**Consultation Response from KC,
Highways Development Management****2024/92809 Popeley Farm, Muffit Lane, Gomersal, Cleckheaton, BD19 4QS****Prior notification for change of use from agricultural building to 1 dwelling****Date Responded: 11/12/2024.****Responding Officer: D. Stainsby****Responding Ref: K9-12NE/4****RECOMMENDATION:**

The proposals are acceptable to Highways subject to details of waste collection being provided, with the location of a waste collection presentation point being clearly marked on a drawing.

## Unit B (B8) site plan as proposed

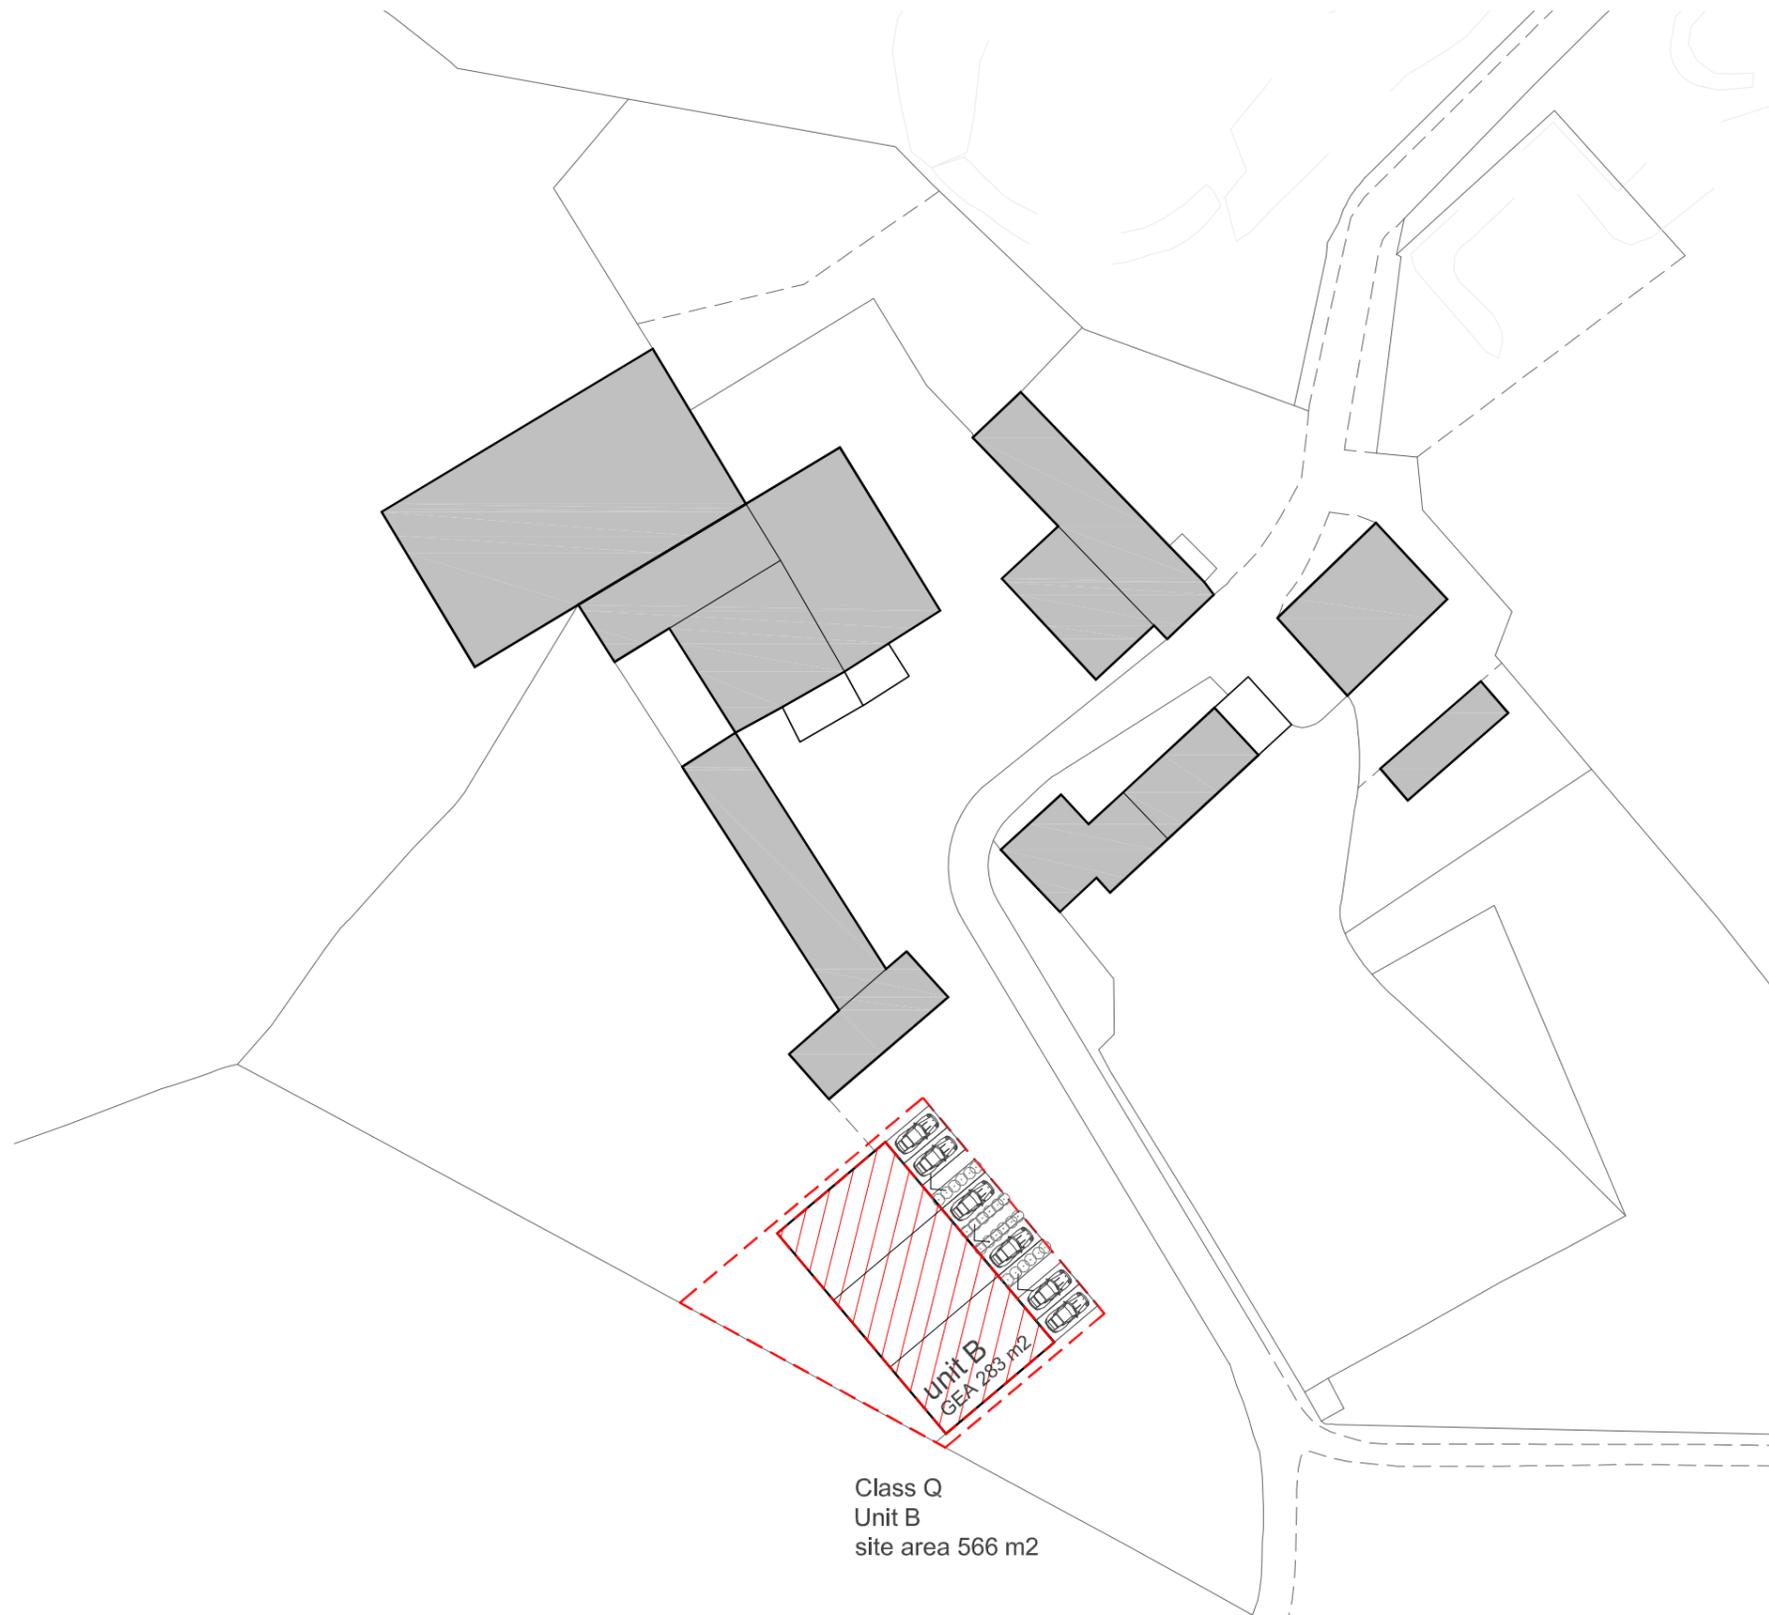
The bin stores are over the minimum carry distance for the refuse collectors and as such a bin collection/presentation point should be located adjacent to the public highway.

Details of the waste collection for the proposed dwelling should be provided, with the location of a waste collection presentation point being clearly marked on a drawing in such a location that is easily accessible to the collection team and where it will not obstruct the access or the adopted highway for road safety reasons.

EXISTING VISIBILITY SPLAYS

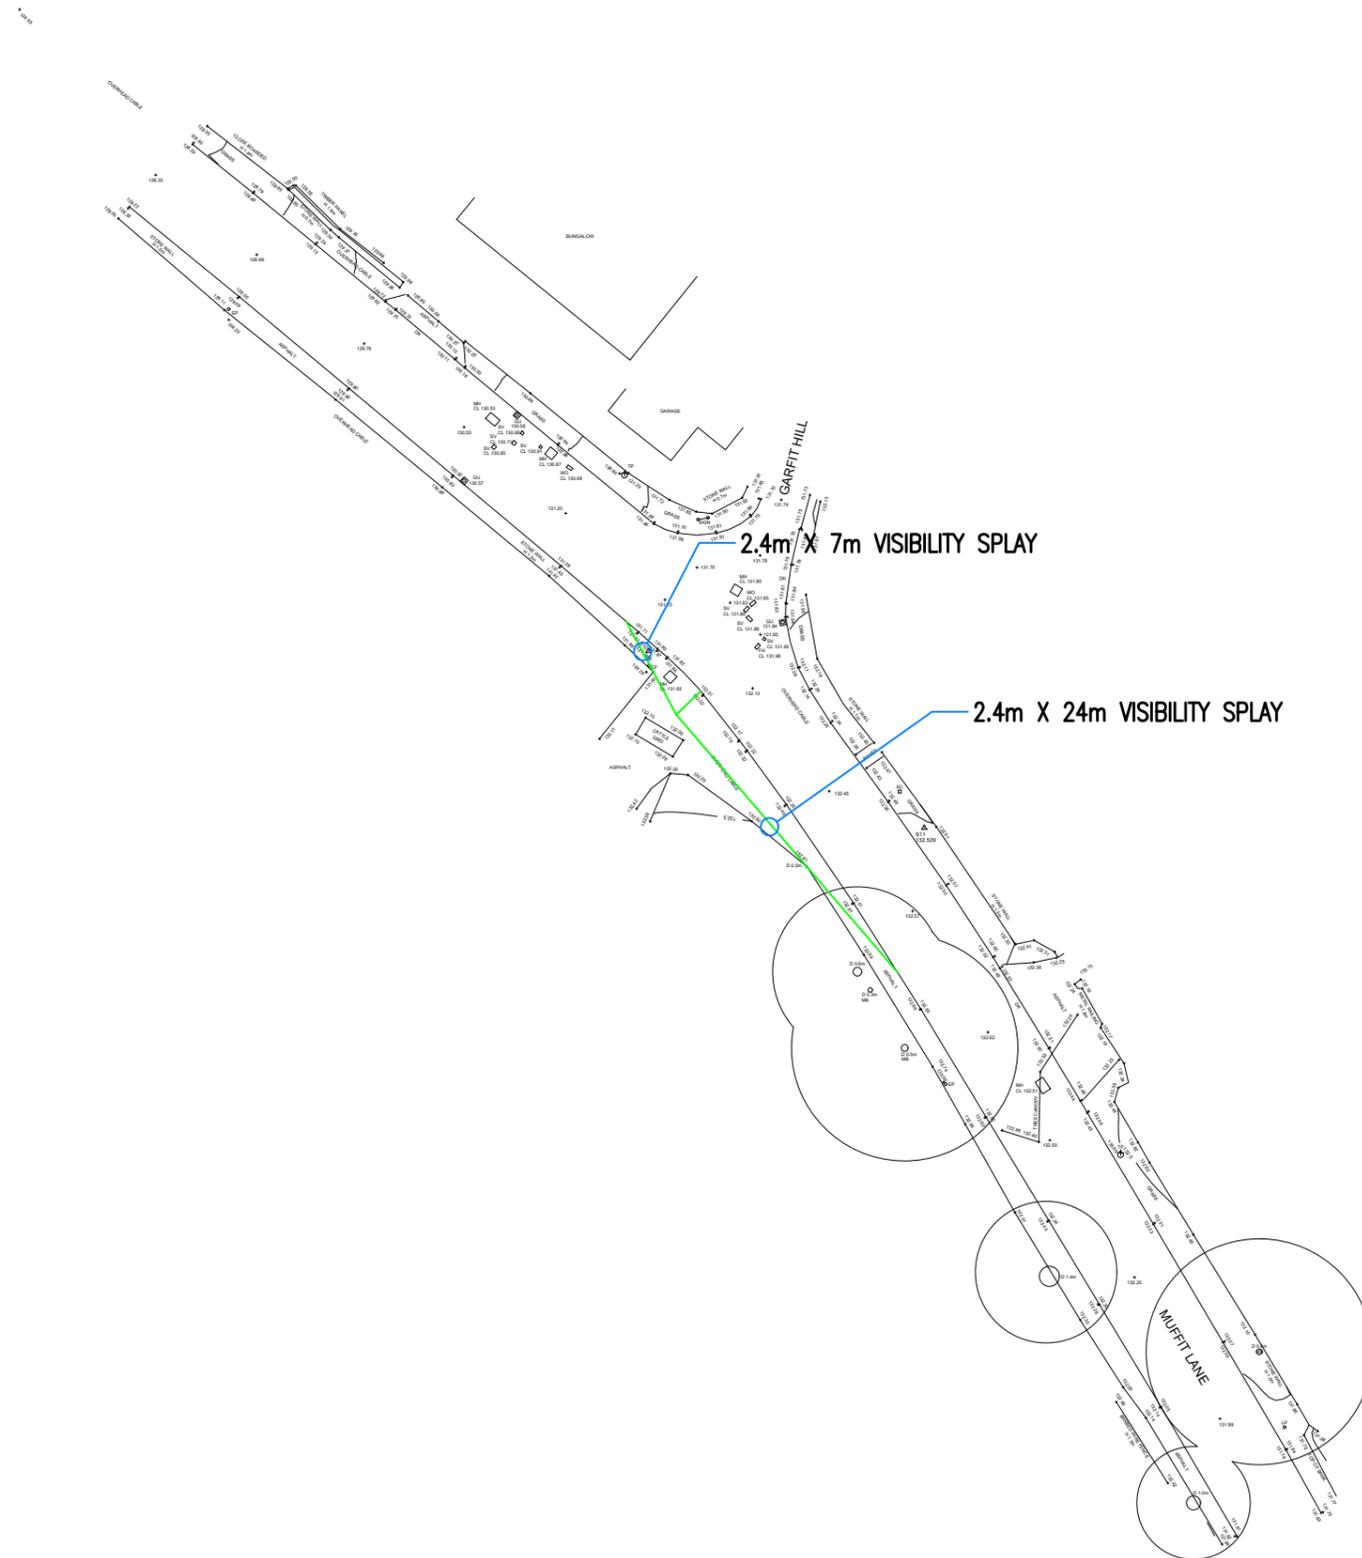
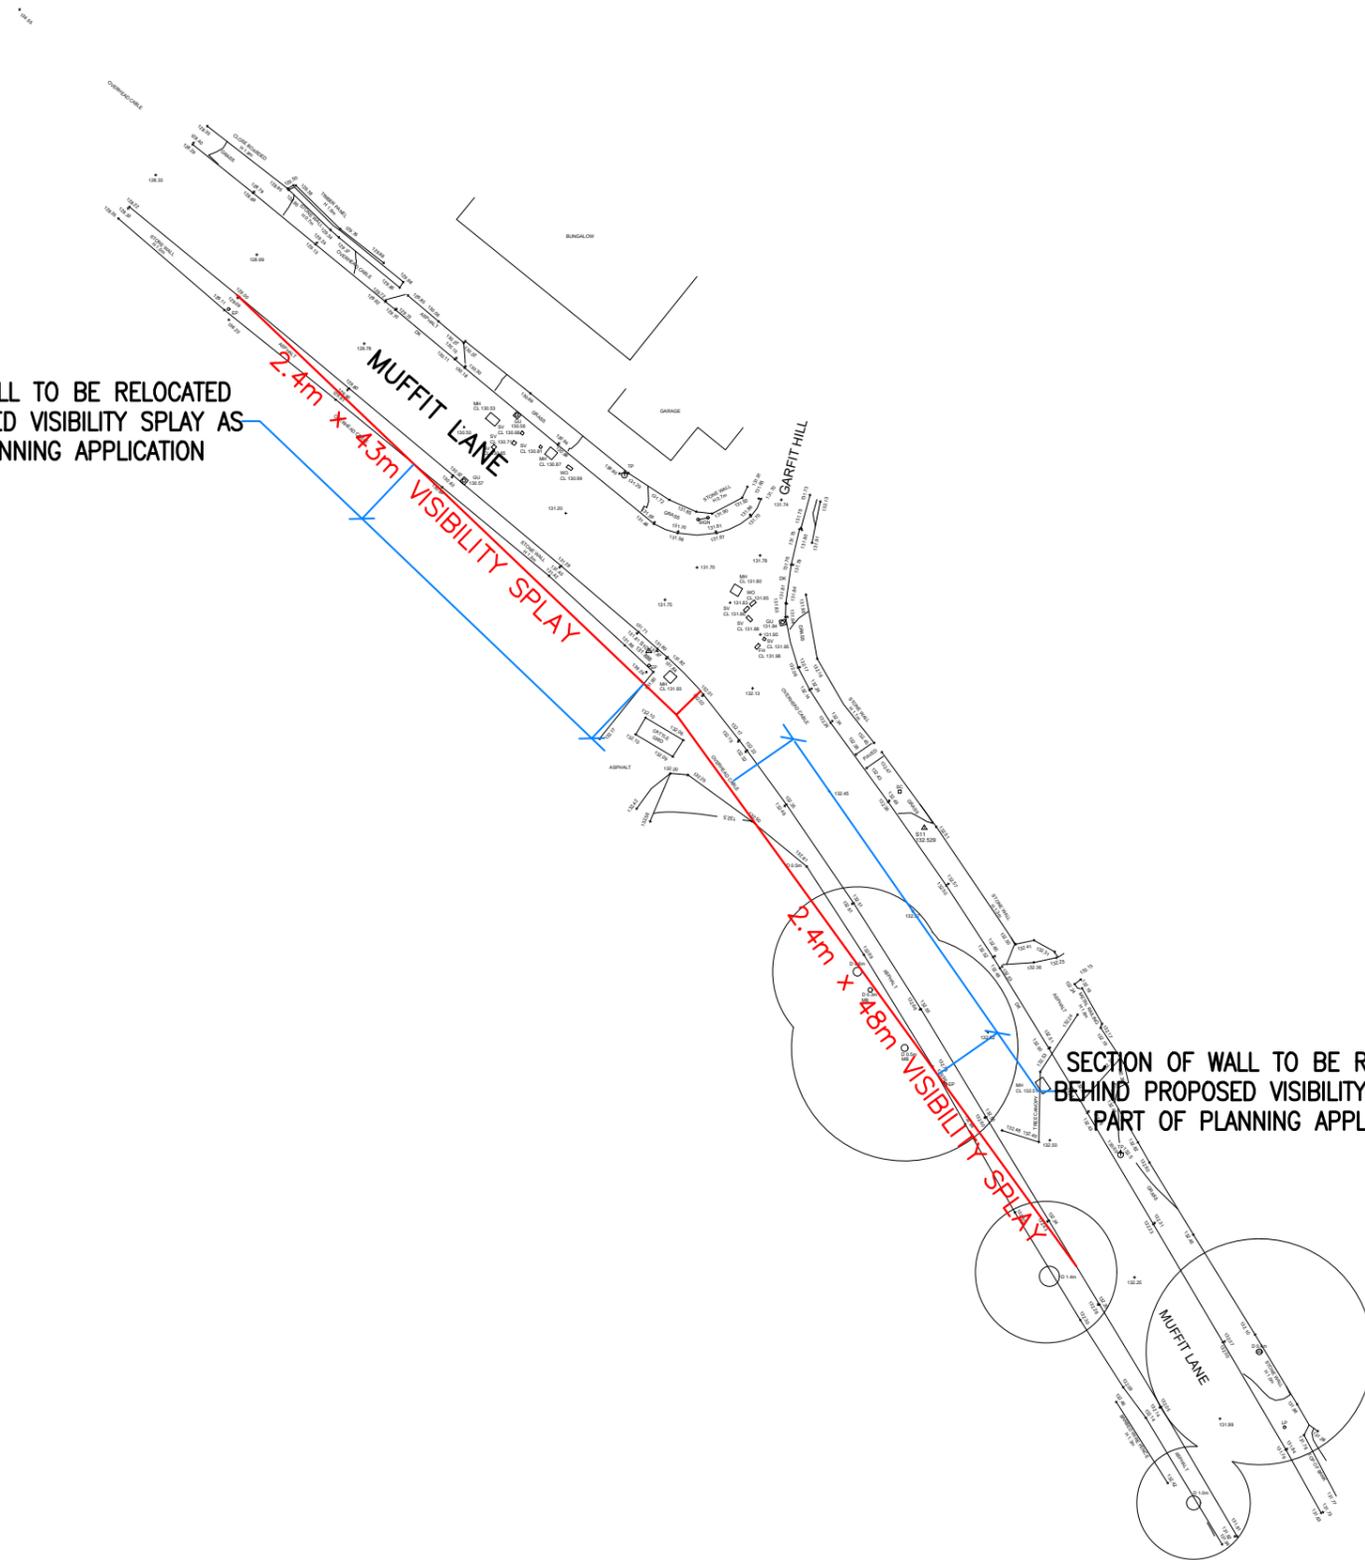
The existing visibility splays are substandard and will need improving. However, the Applicant has now submitted a drawing showing that the recommended visibility splays can be met at this access. These will need to be conditioned for the lifetime of the development.
